Burrendong Wind Farm SSD-8950984

Objection to the Burrendong Wind farm Project.

BWF16 Wallawaugh Road, Hargraves

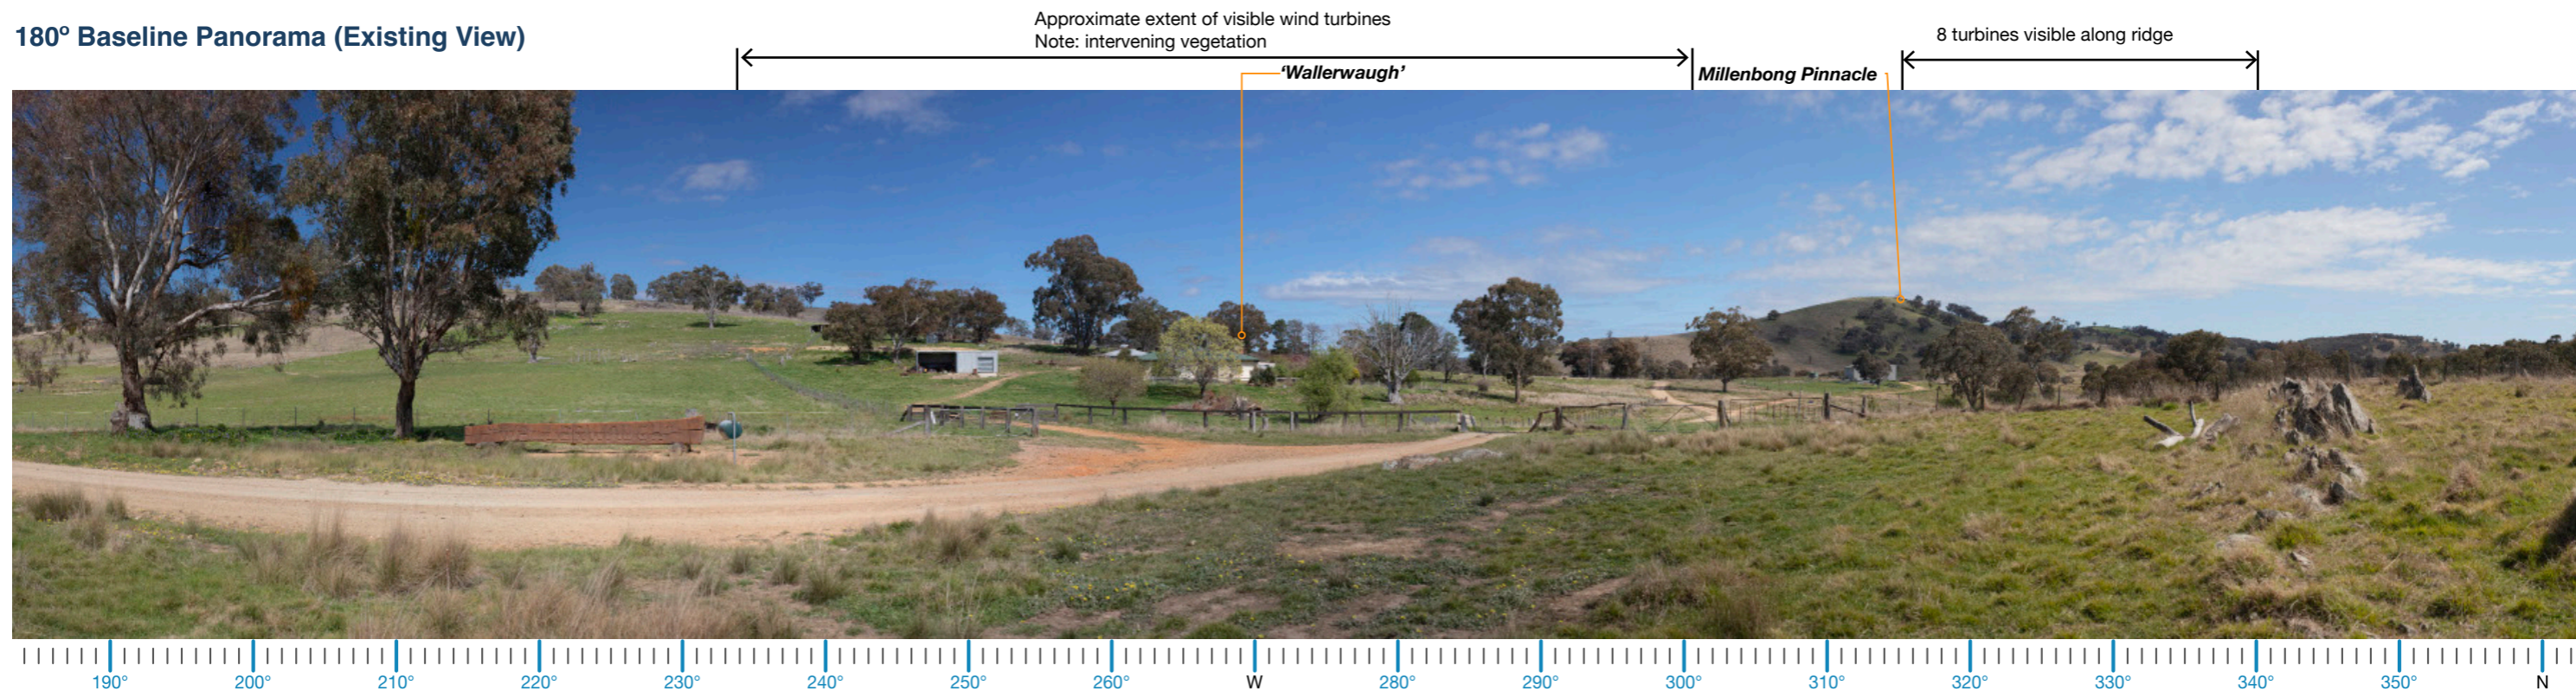
EIS Inaccuracie/s How thorough and accurate is the EIS? For example on page 143 of the EIS, BWF16 is said to be approximately 130 meters south east of Highland Home road intersection, when in actual fact BWF16 is located in excess of 4000 metres south east of Highland Home road intersection. This poses the question, with respect to the entirety of the document, what other inaccuracies may be present.

Figure 1-2: Amended Project Layout

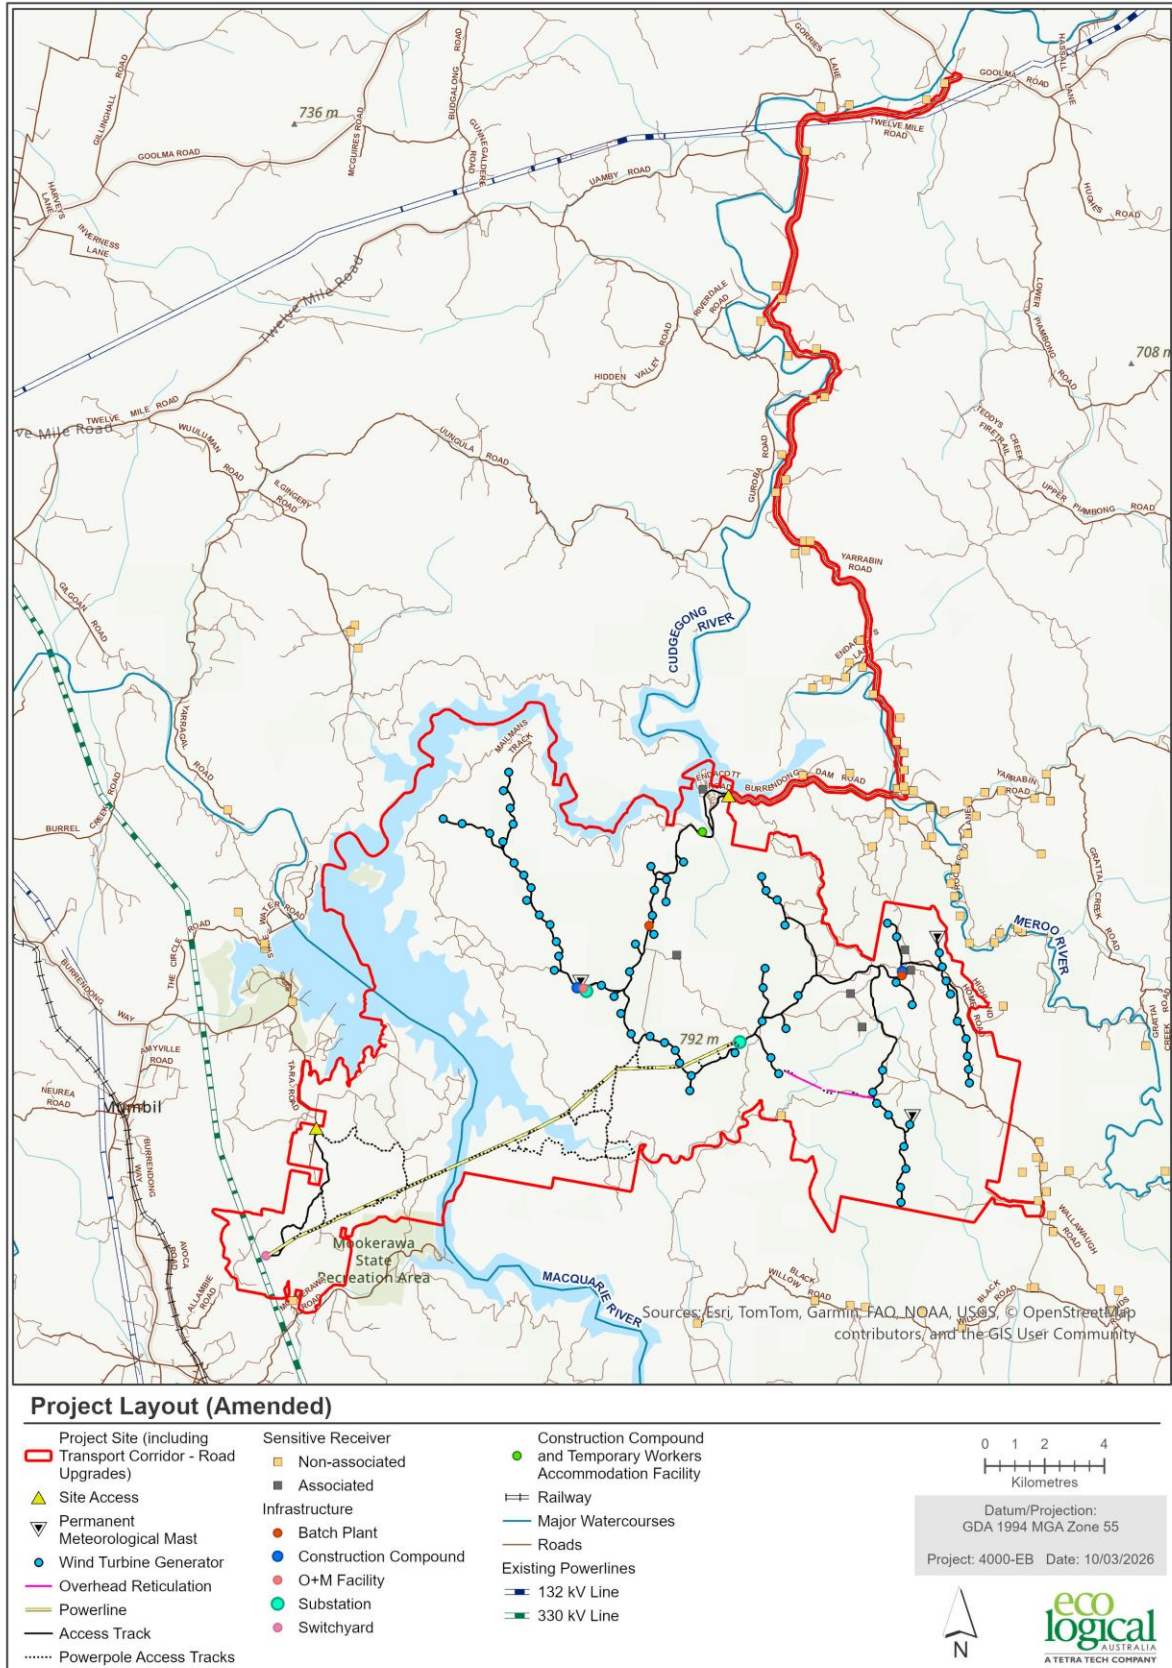
Traffic and Transport In relation to Figure 1-2 (page 27), the diagram outlines all the tracks that will be utilised for the installation and upkeep of the turbines. Will these designated tracks be the only access points used in order to access these turbines. The reason for this query is because, (-32.74748488436545, 149.37842986893594) the coordinates in brackets show a gate entry has been included in the project boundary which is very close to turbines 62,63,64,65,66,67,68,69,70. Due to the close proximity of this existing track (which is not marked on the diagram as a point of access) to the above listed turbines, will it be utilised, and if so will Wallawaugh Rd be subjected to degradation as a result of higher volumes of traffic?
